**Rampion 2 Offshore Windfarm ENO101176  
Written Representation to Planning Inspectorate  
Clymping Parish Council**

**Interested Party Reference number: 20042080**

**Deadline 4 Submission for June 3<sup>rd</sup> 2024.**

**Further Responses following Open Hearing 2 and issue Specific Hearing 2**

Rampton 2 Offshore Wind Farm
 Figure 18.4c: Zone of Theoretical Visibility with viewpoints – Onshore cable corridor

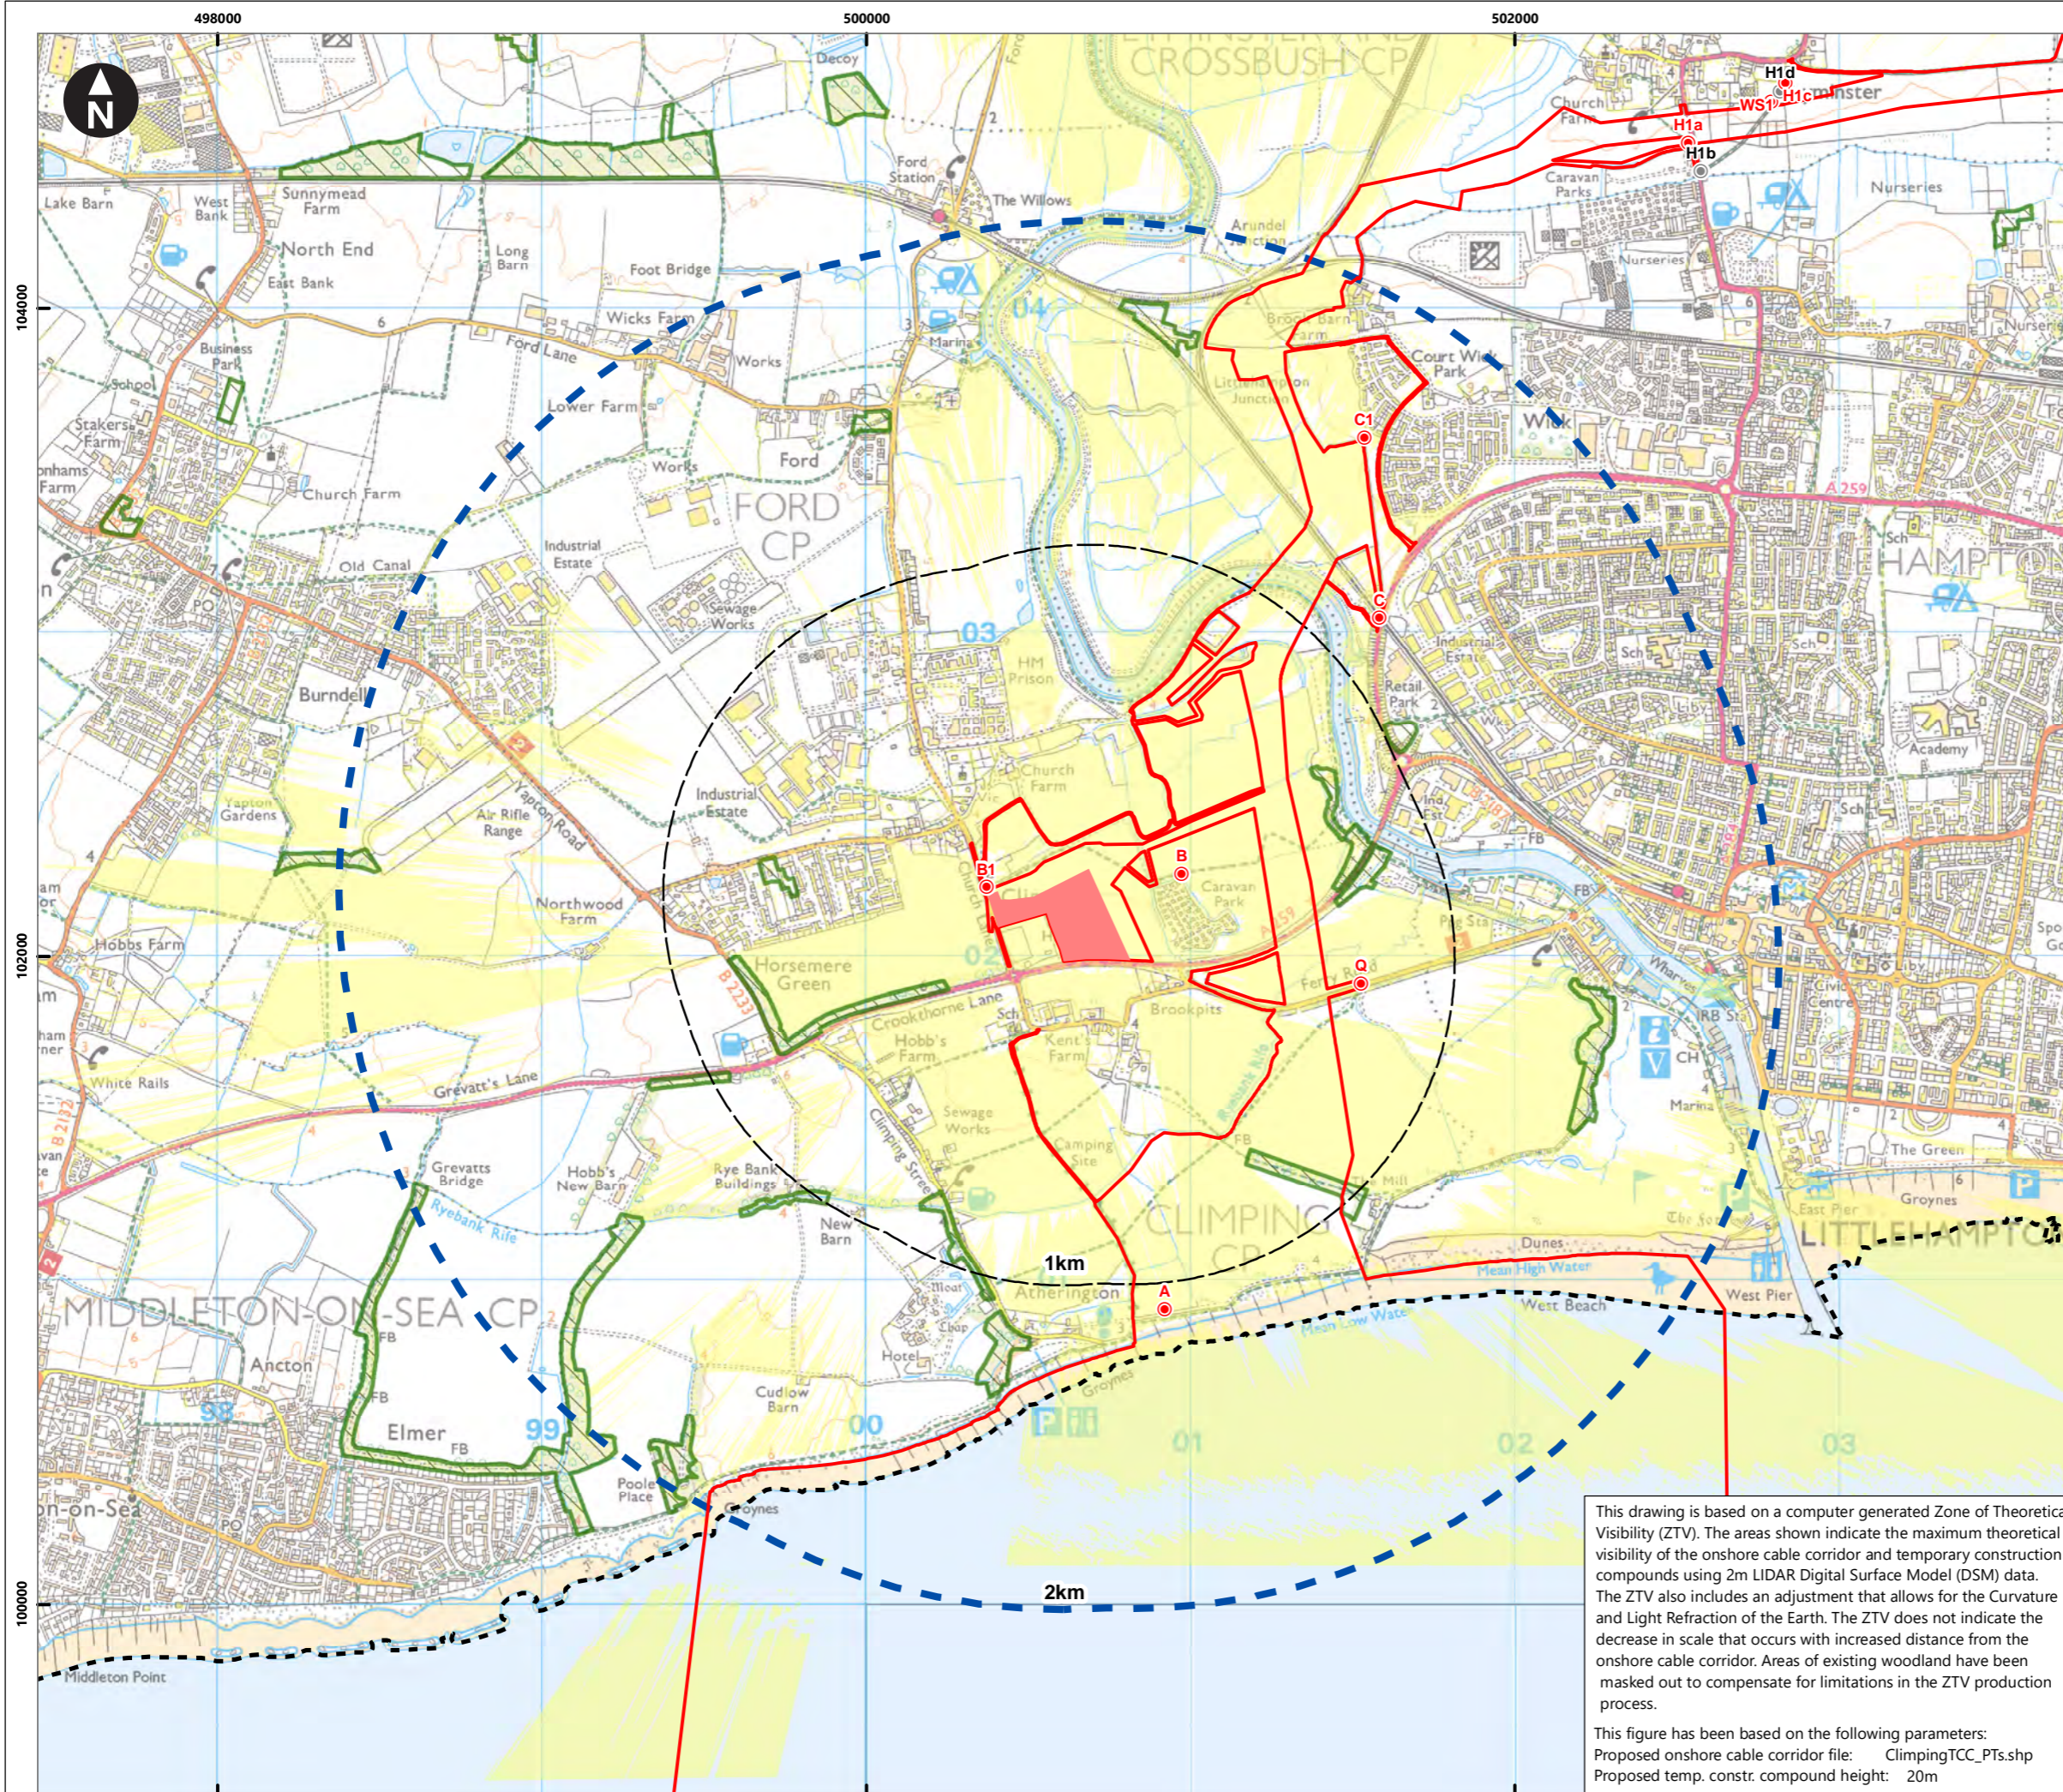
7. The visual impact of the Clymping Compound, the works south of Ferry Road and the lighting proposed for both will be significant in the open landscape. We note equipment heights of up to 7m and, in particular, the concrete batching plant 20m in height that will dominate the views. We want to understand what steps the applicant proposes to undertake to minimise the impact in terms of screening and layout, especially with regards to Climping Park. We have similar concerns for the impacts south of Ferry road in relation to the integrity of the gap between Settlements (Arun Local Plan Policy SD SP3) and impacts on the school and residents in the area including Clymping Mill.

8. The applicant should note that the Construction Method Statement for the Strategic Housing development on the land to the west of Church Lane CM/6/24/DOC envisages the realignment of Church Lane and the removal of the tree canopy on the eastern side of the current Church Lane south of Field Place as part of the first phase of the development. This will leave the Climping Compound/Work Area 10 unscreened from Church Lane.
